Recommendation Report for Lawful Development Certificate for a Proposed Use or Development

REF NO: M/70/21/CLP

LOCATION: 19 Merlin Way
Middleton-On-Sea
PO22 6RN

PROPOSAL: Lawful development certificate for proposed replacement of existing 1.8m side fence with 2.0m side fence (feather edge boards + gravel boards).

Block Plan

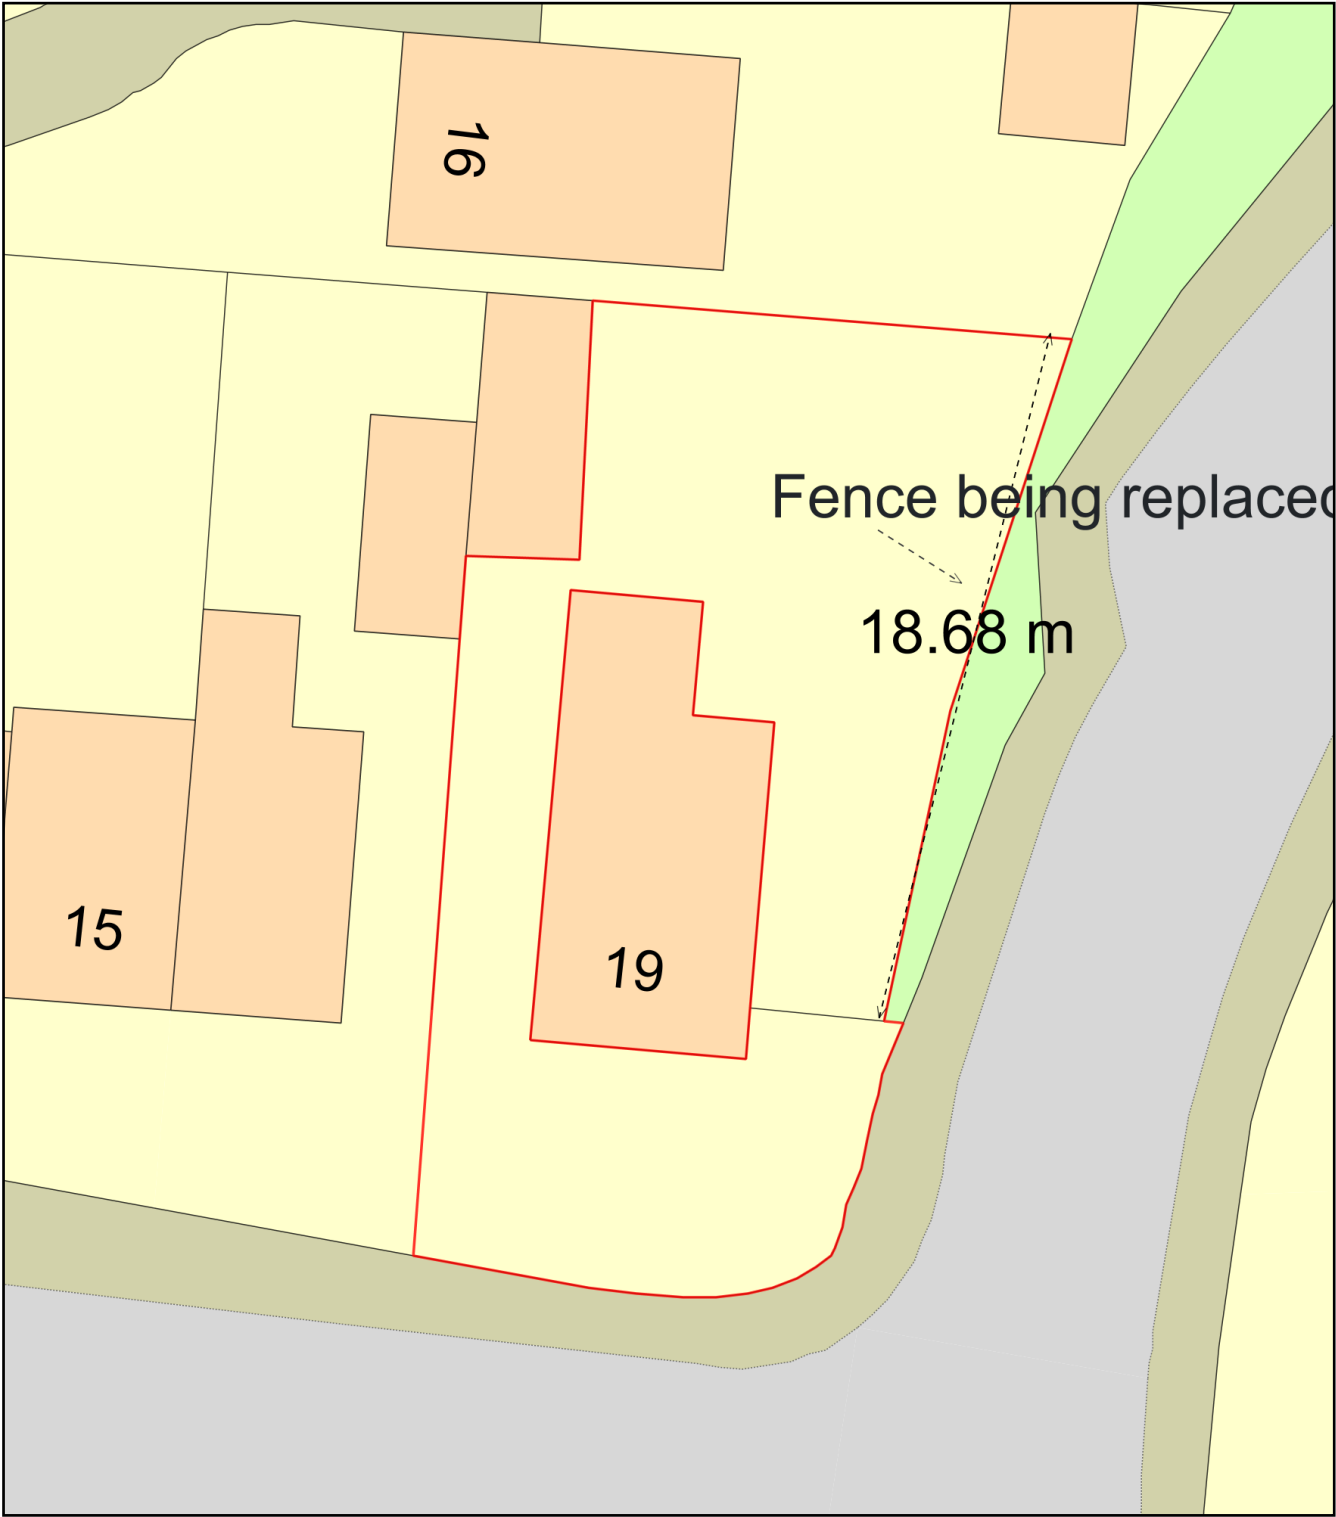
The proposed fence conflicts with relevant sections (a)(ii)(c) in that it is considered to be adjacent to a highway and therefore can not be higher than 1m in height or existing, and is not considered permitted development and as such does require the submission of an application for full planning permission.

2m high fence to eastern boundary of property, adjacent with Moraunt Drive.
